27 January 2021

Sikh Grammar School SSD 9472 and associated subdivision of Lots 42 & 43 DP30186

1.1 Introduction

DRAWING TITLE
DRAINAGE PLAN (STAGE 1)

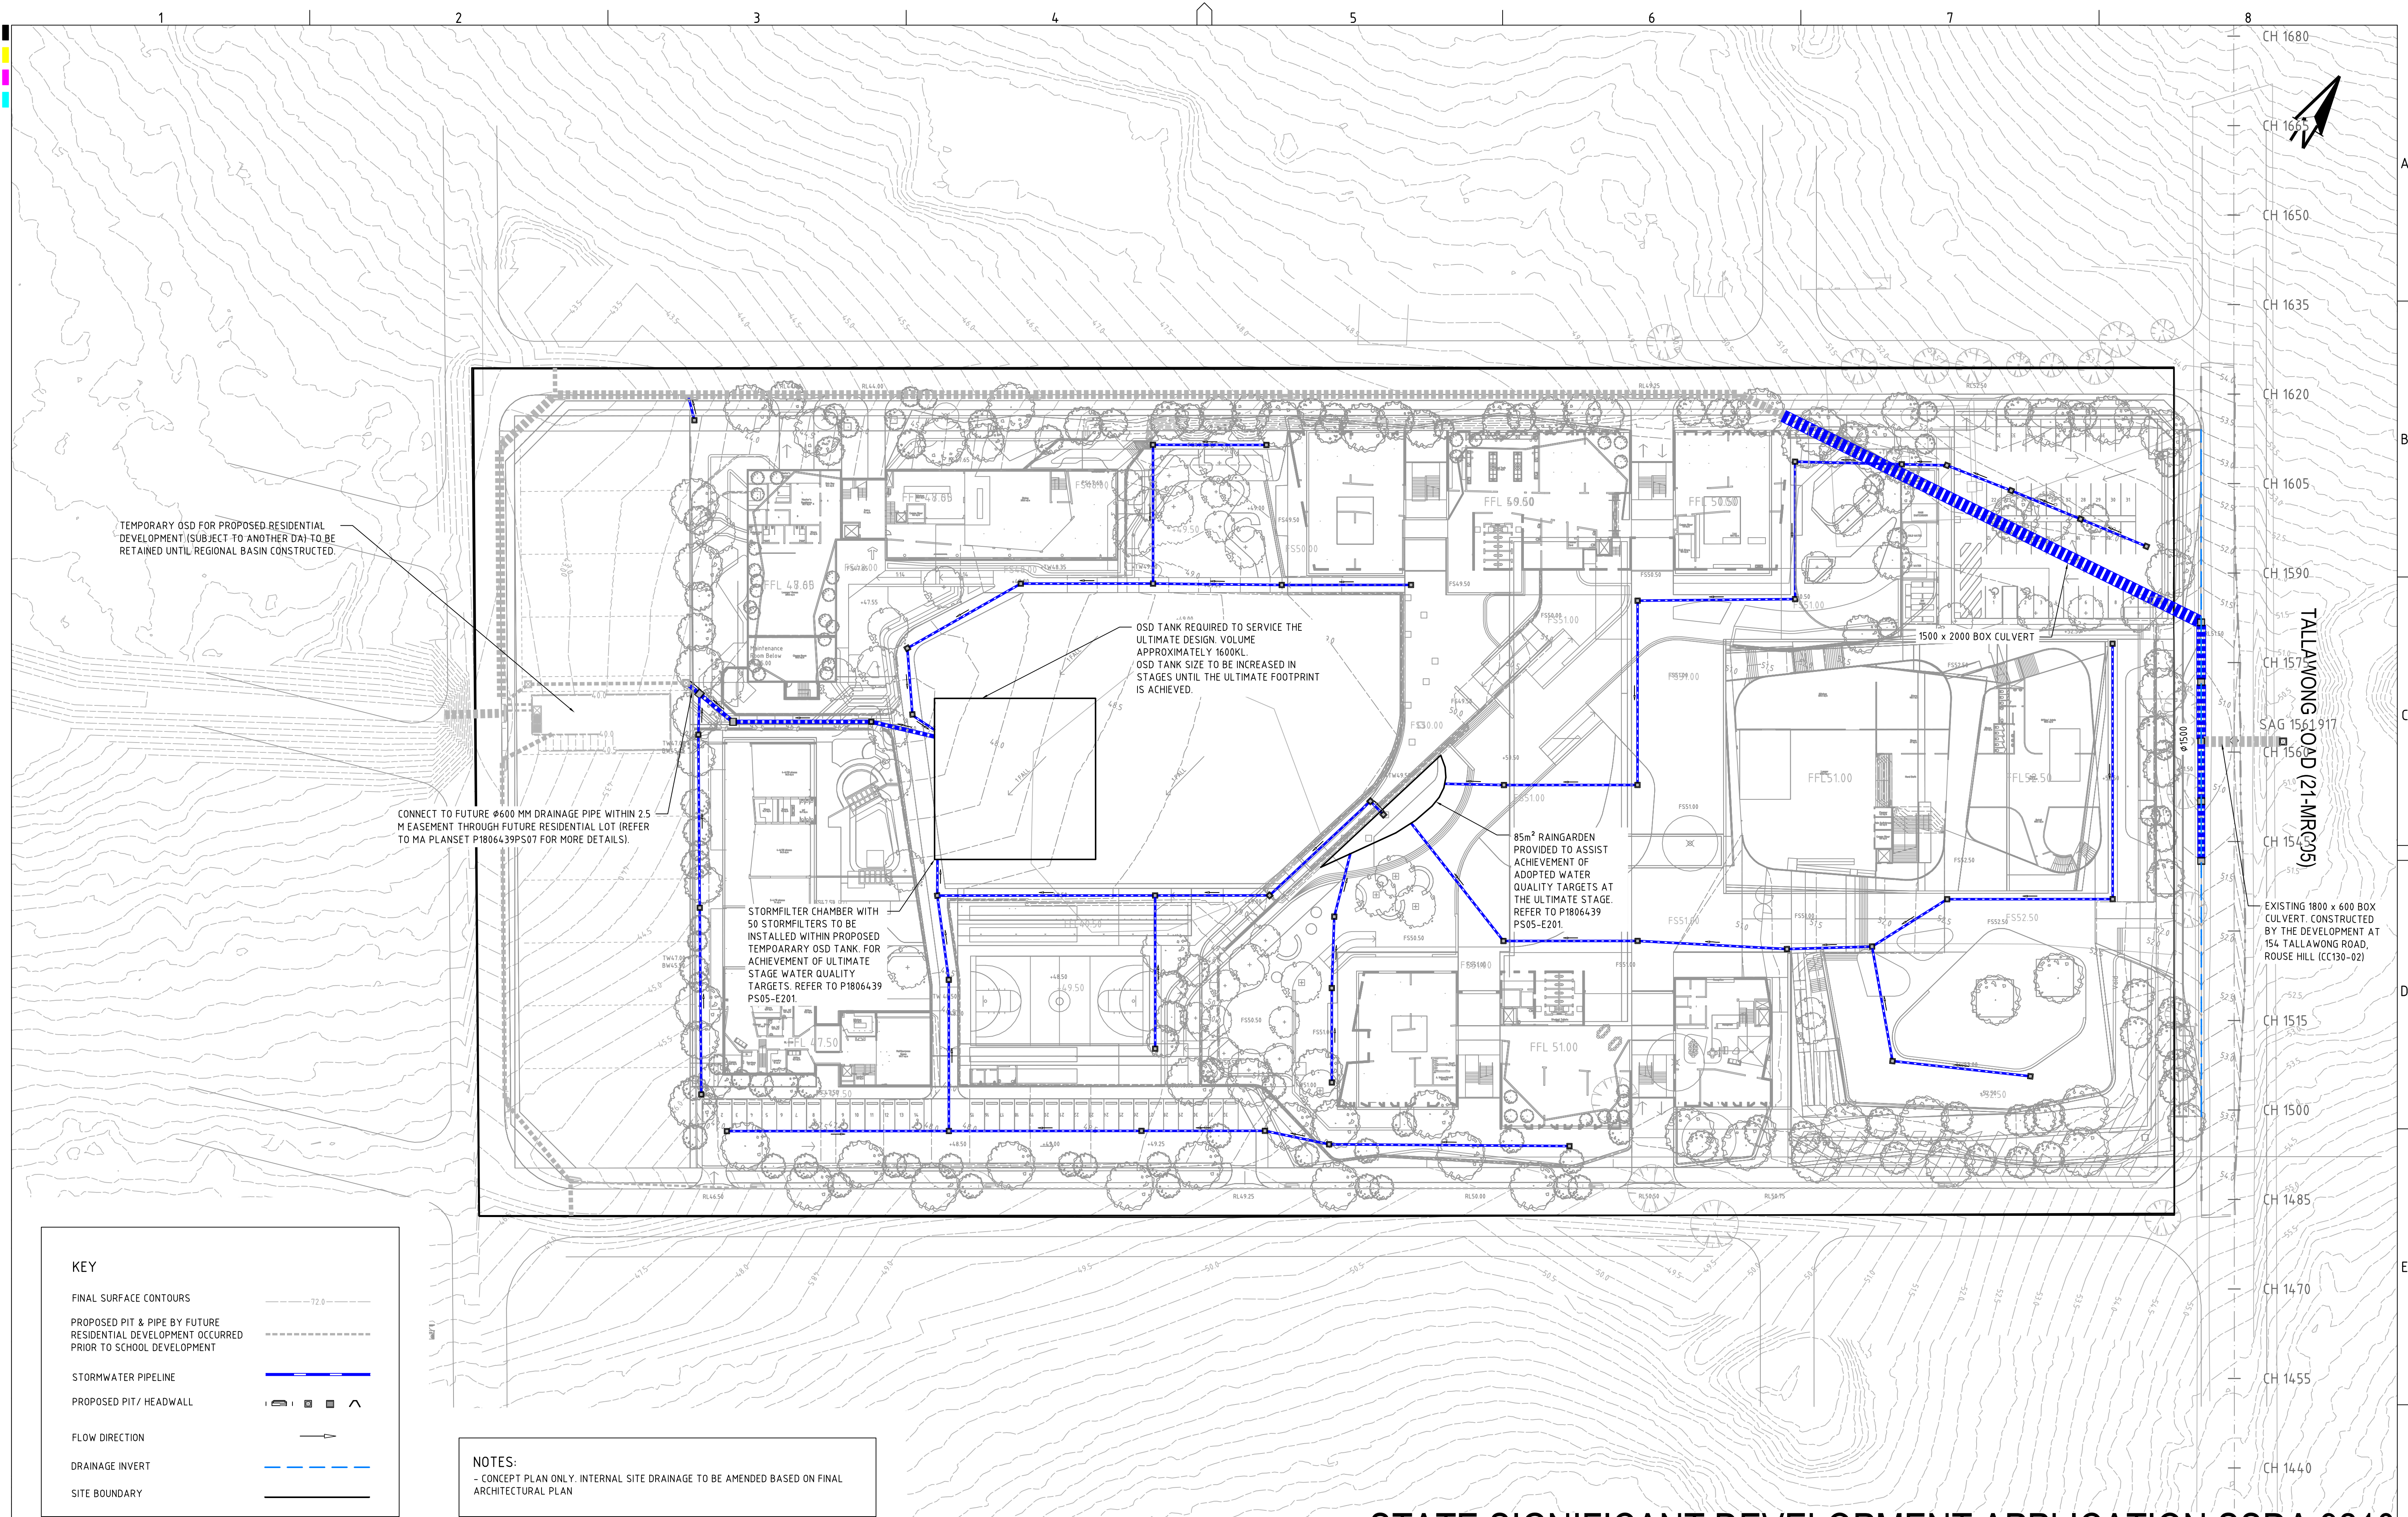
The development application for the school includes a proposal to capture surface runoff from Tallawong Road in 5 x 900mm x 900mm v-grate pits located at the natural sag point in the road adjacent to the school. A 1500mm diameter pipe is proposed to connect these pits to a box culvert proposed under the at-grade carpark in the north-east corner of the site. An overland flow path would also be formed across this carpark.

1. The DA documents provide conflicting dimensions for the proposed box culvert under the proposed north-eastern carpark. One section of the *Concept Stormwater Management Plan and Preliminary Flood Study* states dimensions of 2000mm x 1800mm and another states dimensions of 2000mm x 1500mm. The correct proposed size should be confirmed.

2. The proposed 2000mm x 1500mm (or 2000mm x 1800mm) box culvert exceeds the size of the proposed downstream 1500mm diameter pipe (to be constructed as a component of the related subdivision works) that the culvert would connect to. The proposed box culvert has a capacity that Council has estimated would be more than double that of the downstream pipe. The proposed arrangement creates a potential 'choke' point in the system that could lead to surcharging at this location if blockages occur where the larger box culvert reduces to the smaller pipe, or where flows along the box culvert exceed the capacity of the pipe.

3. It is unclear from the application why a larger box culvert is proposed upstream of the smaller 1500mm diameter pipe proposed as a component of the related subdivision works. If the 1500mm diameter pipe has sufficient capacity to convey the 1% AEP flow it is unclear why a larger box culvert is being proposed upstream. The applicant should confirm the reasoning for the size difference.

5. The application assumes that surface runoff from Tallawong Road during the 1% AEP event draining to the sag point adjacent to the site would be captured by 5 x 0.9m x 0.9m flush v-grated pits. It is considered that this arrangement is likely to readily become blocked by organic debris and other matter during large runoff events due to the small openings provided in the flush grates. Typically, sag points should be provided with larger raised inlets (e.g. kerb inlets or raised grates) that are less susceptible to blockage. Additional inlets formed in the kerb at a higher level to the v-grate inlets may assist to mitigate impacts of potential blockage.
